DEPARTMENT OF PARKS AND COMMUNITY SERVICES

May 9, 2024

Subject: Greaves Vacation Replat (VR243)

# GREAVES SUBDIVISION FILING NO. 1

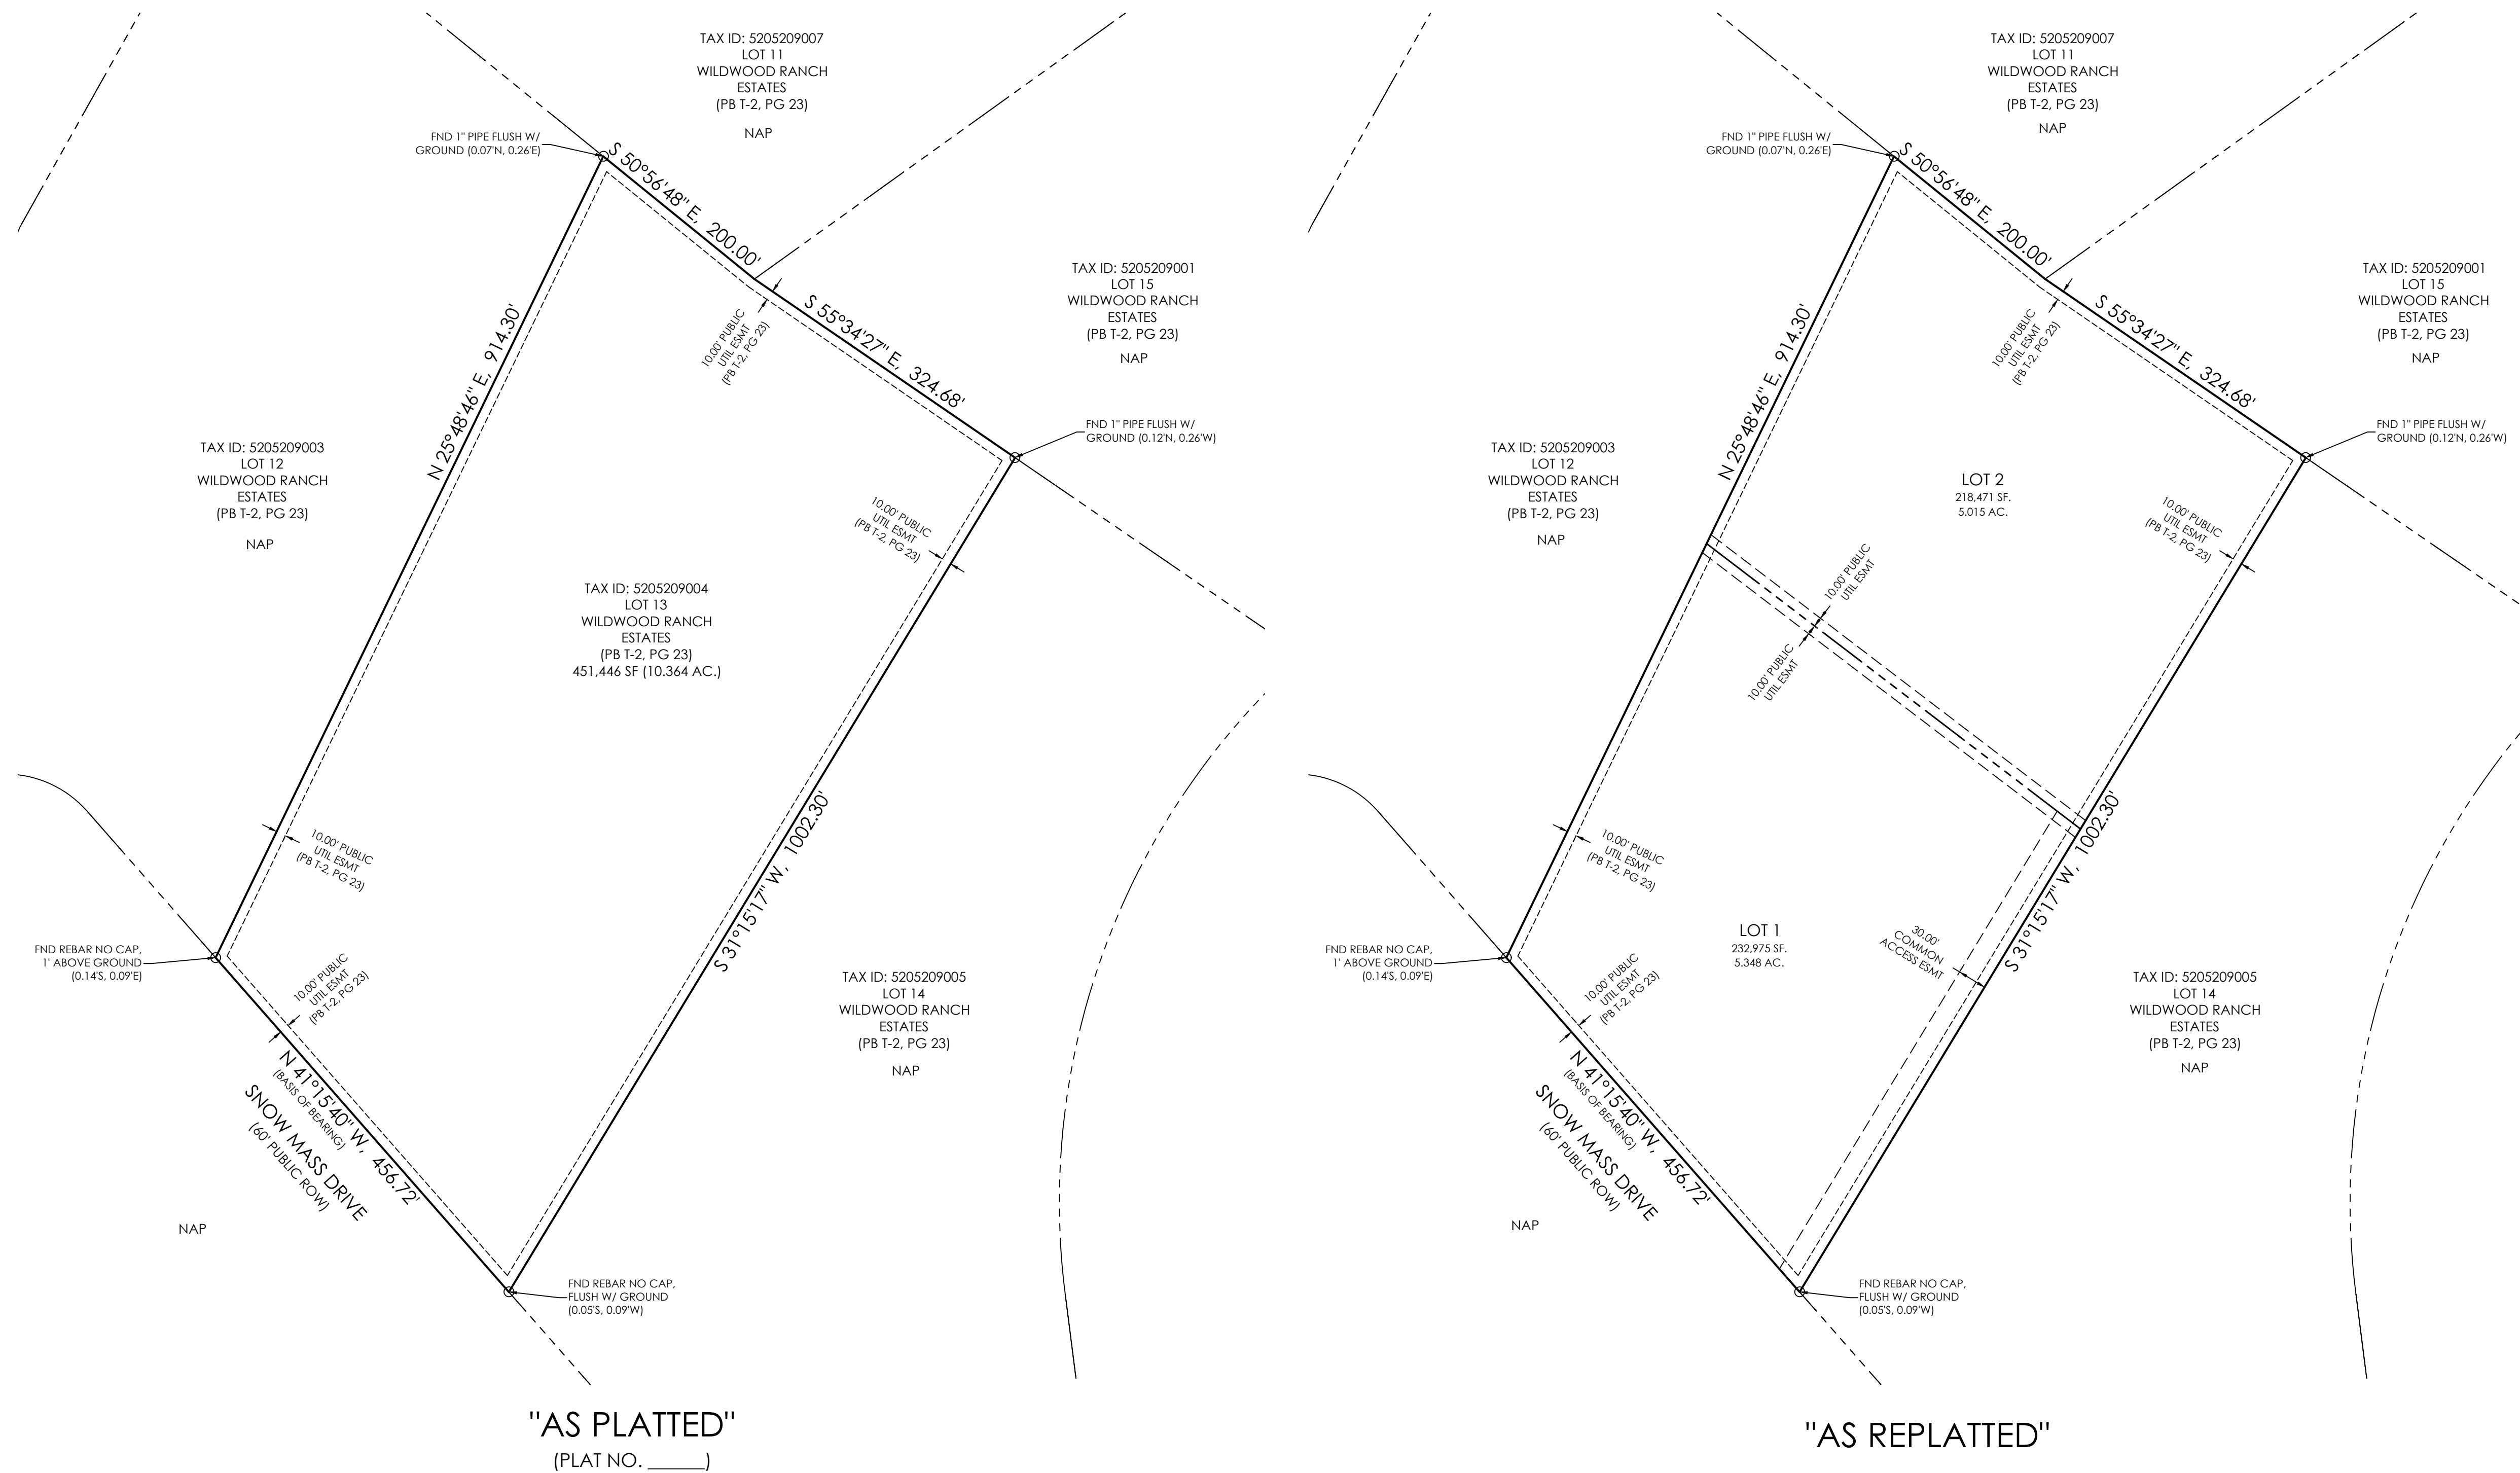
The 2022 El Paso County Parks Master Plan shows one master-planned county trail being impacted by this application. The Palmer Divide Primary Regional Trail is located along Snow Mass Drive, which will provide a connection between Black Forest Regional Park and Pineries Open Space. Consistent with LDC requirements, County Parks will require trail easements where proposed projects impact county trails. For this application, a 25-ft wide public trail easement will be sought along the southern boundary of the site along Snow Mass Dive to allow for the future construction and public use of the trail.

The Park Advisory Board recommends that the Planning Commission and the Board of County Commissioners include the following conditions when considering and/or approving the Greaves Vacation Replat: (1) require fees in lieu of land dedication for regional park purposes in the amount of \$920 be due at recording of the final plat; (2) show on the final plat and dedicate to El Paso County a 25-foot trail easement, along the southern boundary of the site parallel to Snow Mass Drive.
